**ADC Planning Consultation
Conservation/Design Officer Response**

Application Number	R/131/17/PL
Address	Land Adjacent Abbots Lodge 85 The Street Rustington BN16 3NL
Description	6 No. one bed apartments. This application affects the character & appearance of the Rustington Conservation Area and a Listed Building.
Case Officer	<u>Mr D Easton</u>
Date	31.10.17

NORTH ELEVATION [Existing Building - Abbot's Lodge]

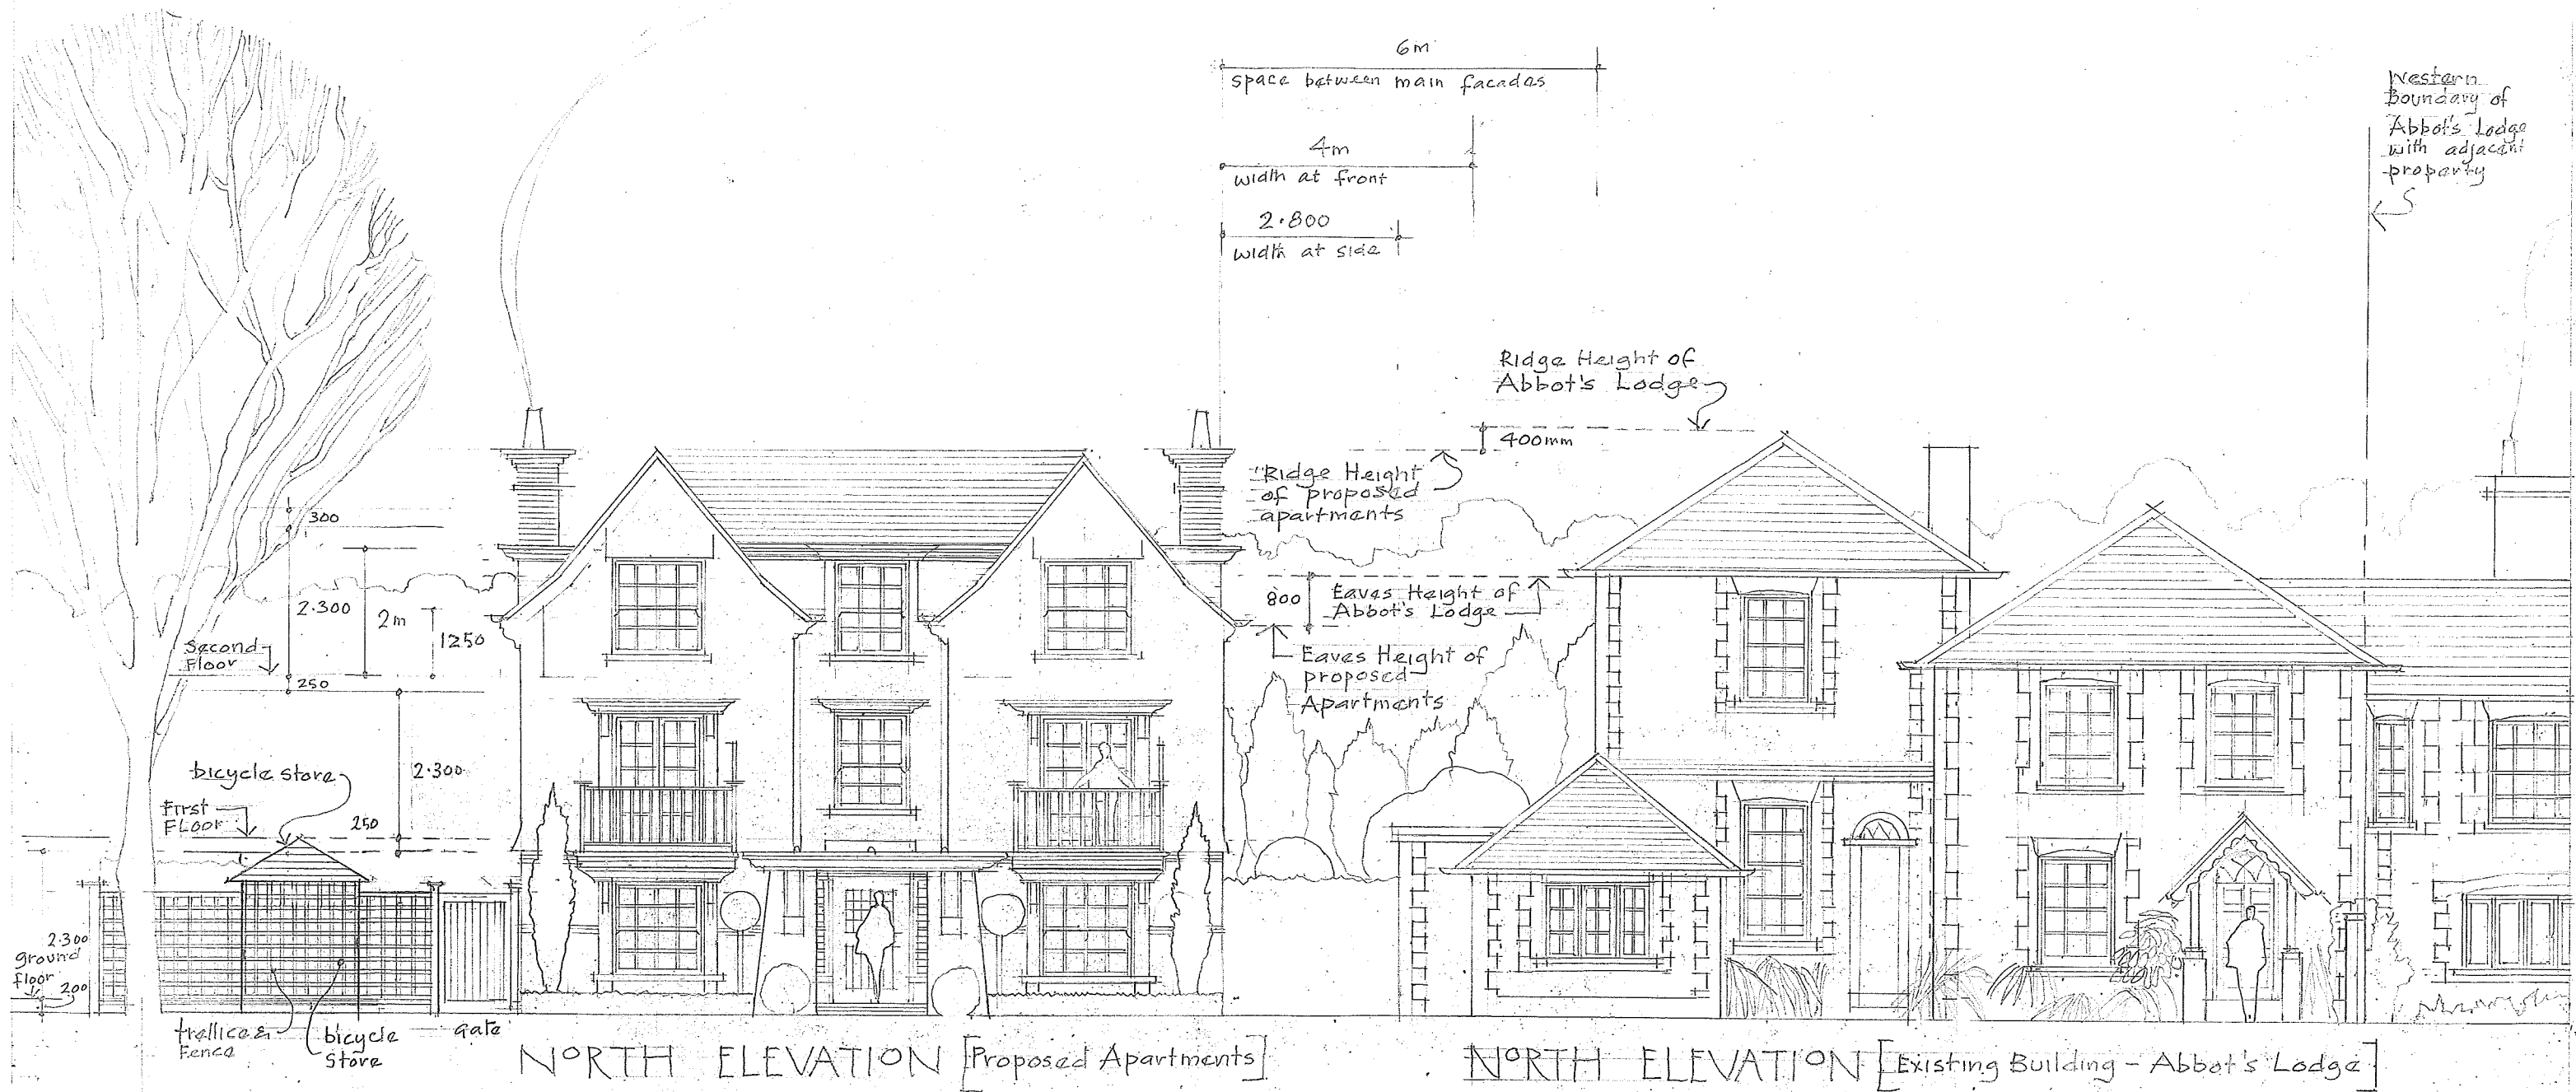
It is considered that the proposal would compromise the special character of the Conservation Area as overly dominant in terms of its massing and siting within the plot. The proposal would also be highly visible looking into the Conservation Area from The Grangeway, Claigmar Road and looking East along The Street.

The relationship of the proposal with the listed Abbots Lodge is uncomfortable and is considered visually dominant in relation to the heritage asset, its setting and that of the Conservation Area. The proposal is of three storeys, which is more than is

ABBOT'S LODGE · HIGH STREET
RUSTINGTON
A PROPOSAL FOR A DEVELOPMENT OF
SIX-ONE-BEDROOMED APARTMENTS
ON THE SITE TO THE EAST OF THE LISTED
DRAWING N°5 BUILDING

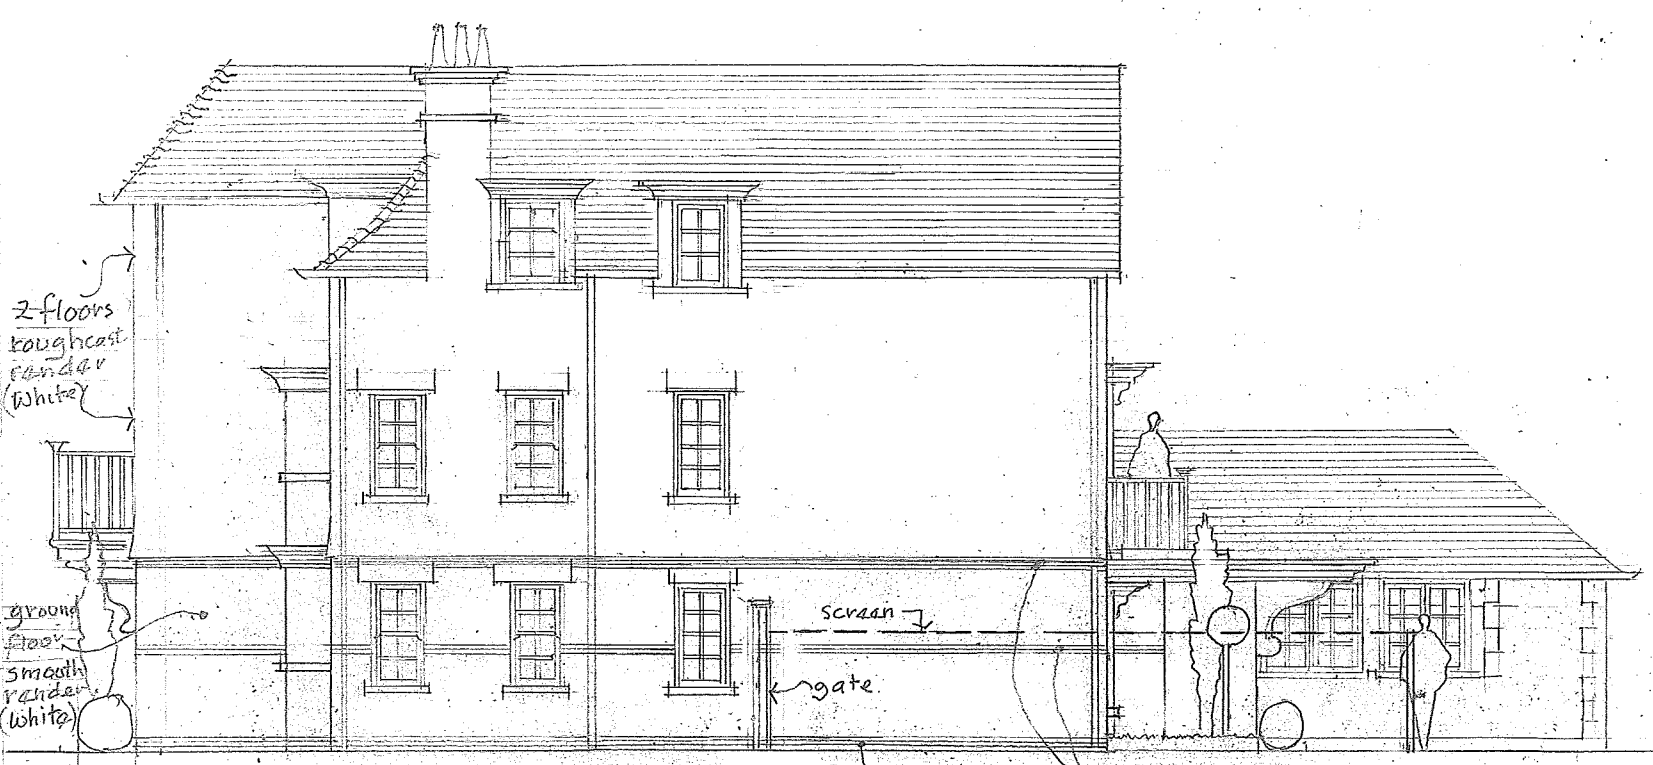
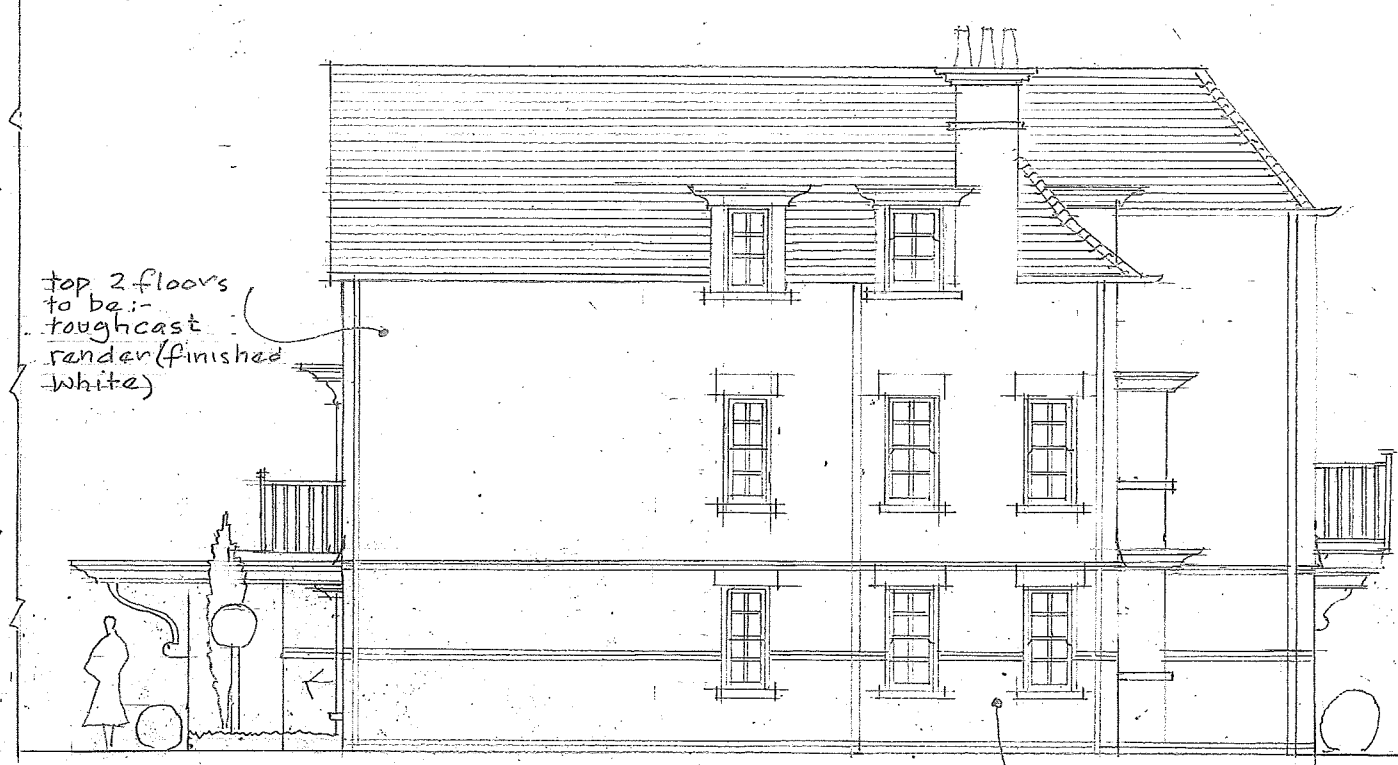
typical of the area, with rendered finish and general detailing - including white metal balconies - is considered both out of character with the surroundings, and fails to make a positive contribution to it. In addition to the building itself, the application notes the breaching of the historic flint wall to make new vehicular and pedestrian access; the creation of 10no. parking spaces to the front of the plot; and the erection of a street-facing timber cycle/bin store. It is considered that the hard landscaping, lighting and proposed paving surround the proposed building would be detrimental to the setting of the listed building and the character of the Conservation Area.
